Our Reference: SYD15/00996/14 (A19971568)
DP&E Ref: SSD 7173 MOD 2

**PROPOSED SECTION 96(1A) MODIFICATION TO ALTIS WAREHOUSE AND LOGISTICS HUB
585-649 MAMRE ROAD, ORCHARD HILLS**

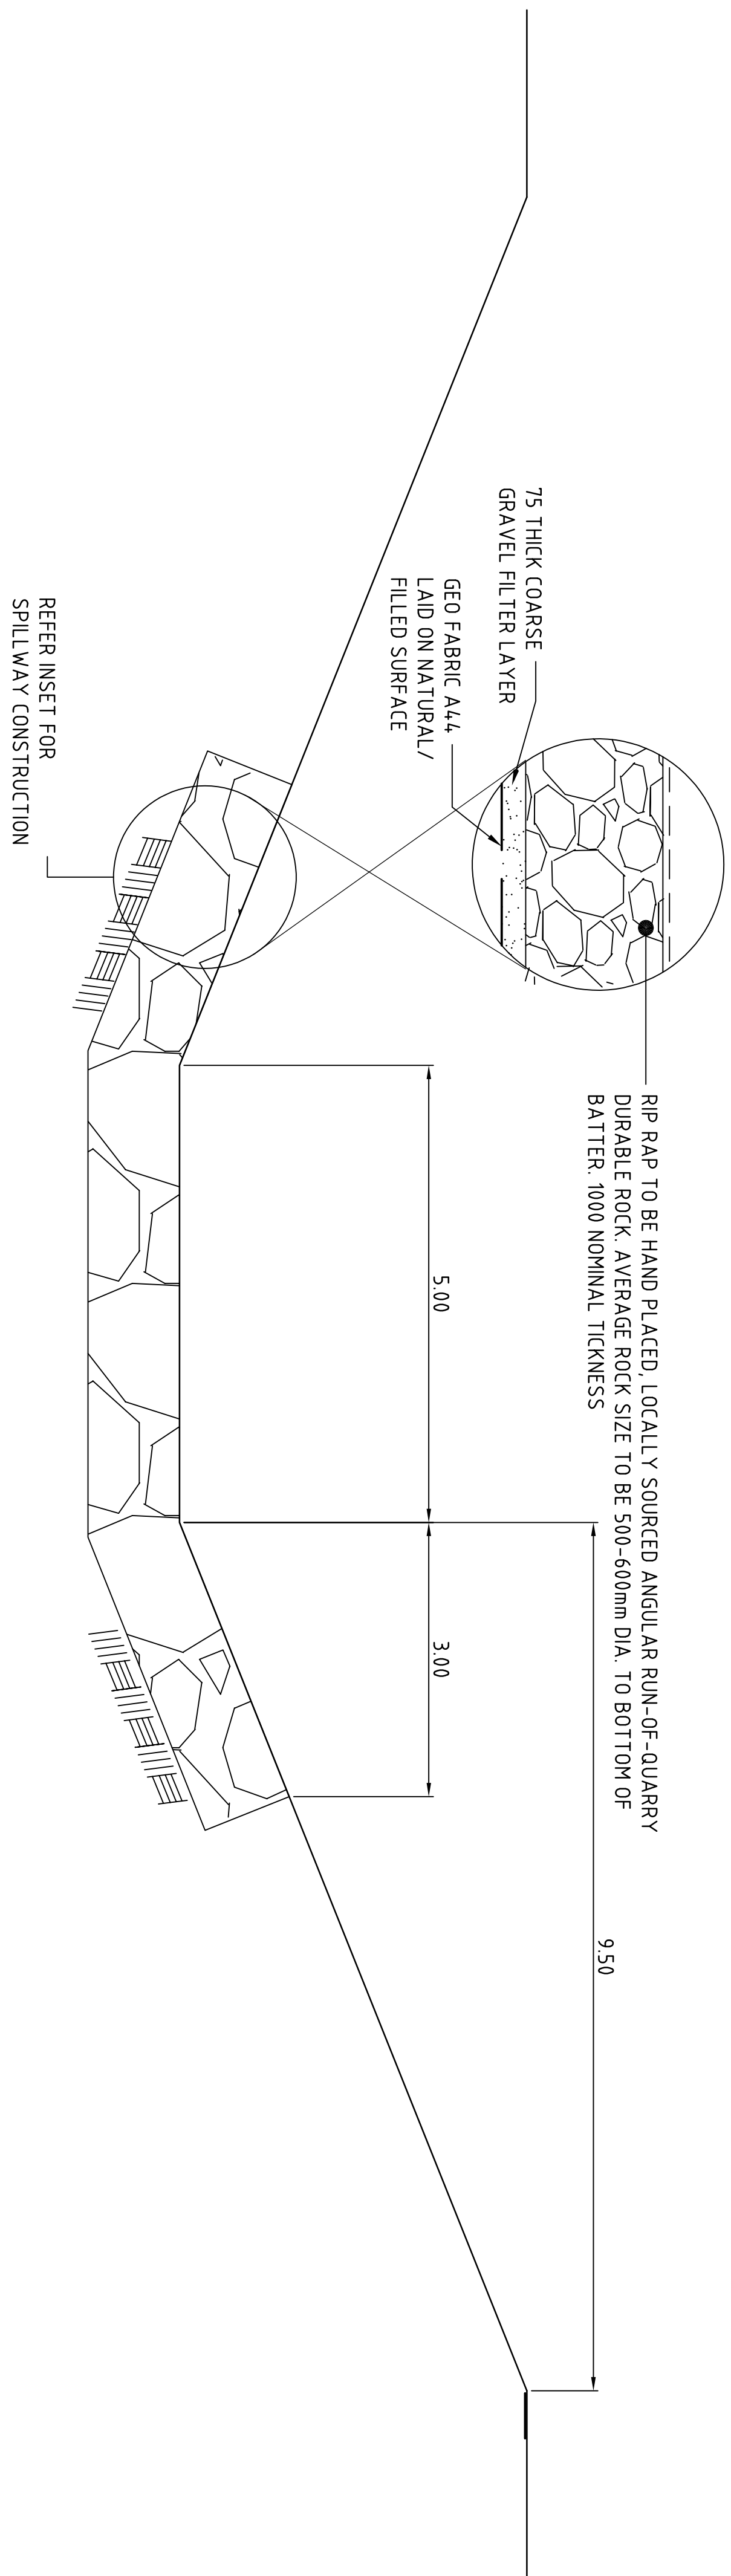
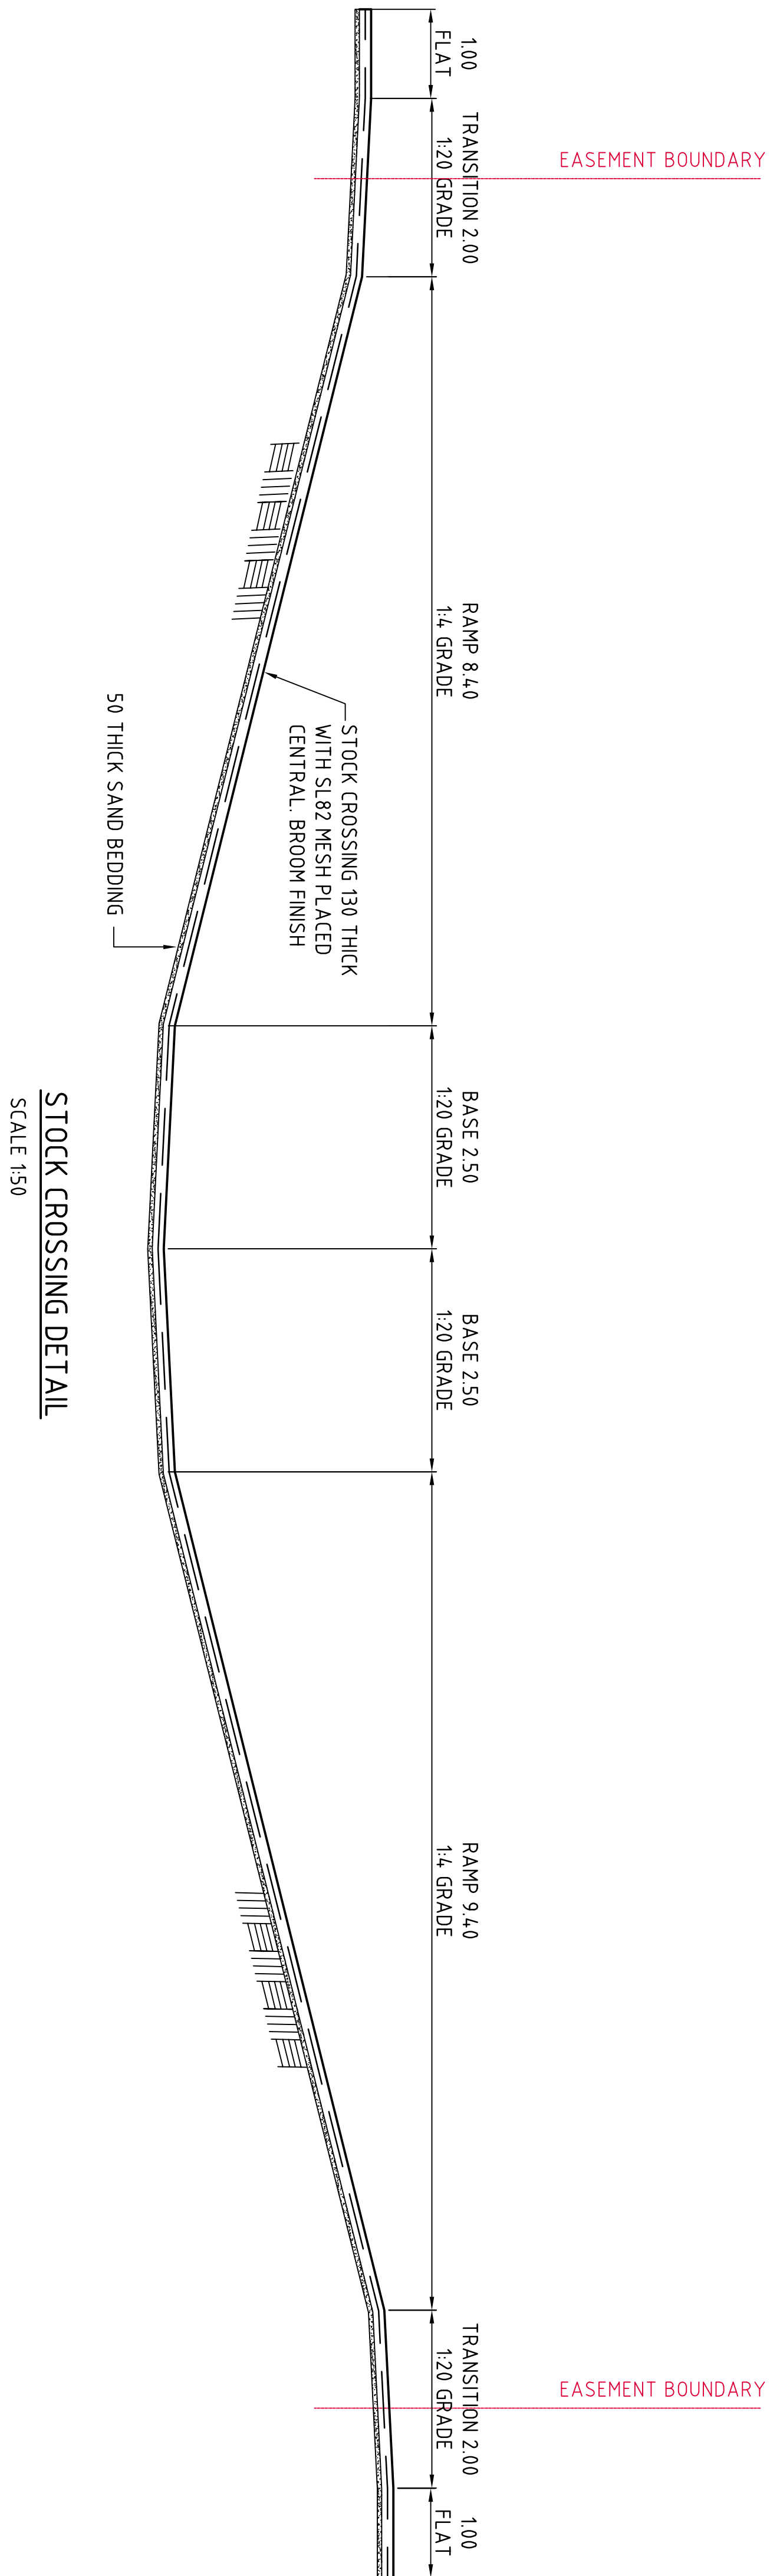
1. It is noted the Estate Drainage Channel is proposed to be realigned as part of the proposed modifications. Therefore, detailed design plans and hydraulic calculations of any changes to the Roads and Maritime's stormwater drainage system are to be submitted to Roads and Maritime for approval, prior to the commencement of any works.
